Introduction

This document represents Surrey County Council's response to TR020005 AS-121 ([Accounting for Covid-19 in Transport Modelling](#)). Although the results of the post-Covid forecast shows a lower level of baseline traffic than previously forecast in the DCO Application, the impact of the GAL NRP traffic on the network is now proportionally greater. Indeed, as there is now less baseline congestion in this post-Covid forecast, car travel is more attractive, resulting in a lower public transport mode share. Crucially, it shows that in 2032, GAL is not able to meet the mode share targets set out in the SACs for both passengers and staff. SCC agrees with TR020005 AS-121 para 6.5.10 that the SAC should not be changed but is concerned that despite failing to meet targets in 2032, no further mitigation is proposed.

Figure 15: AADT difference, 2047 with Project sensitivity test less 2047 future baseline sensitivity test

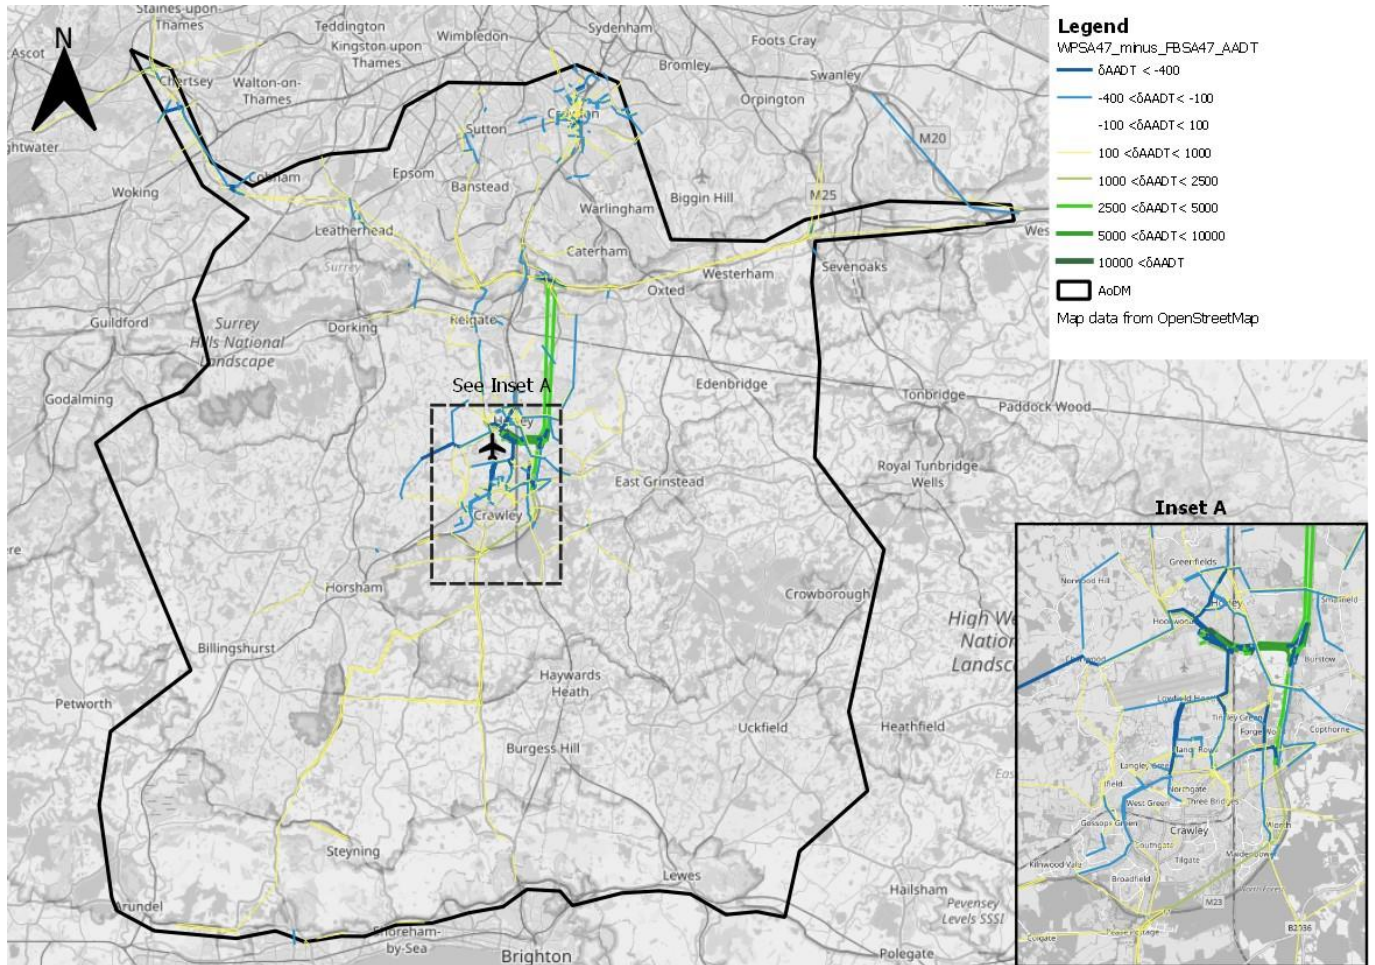
- Figure 15 shows there are a number of local roads to the west of the Airport and in Horley that experienced reductions in AADT in the Application, that now show small increases in AADT in the sensitivity test (para 6.6.15).
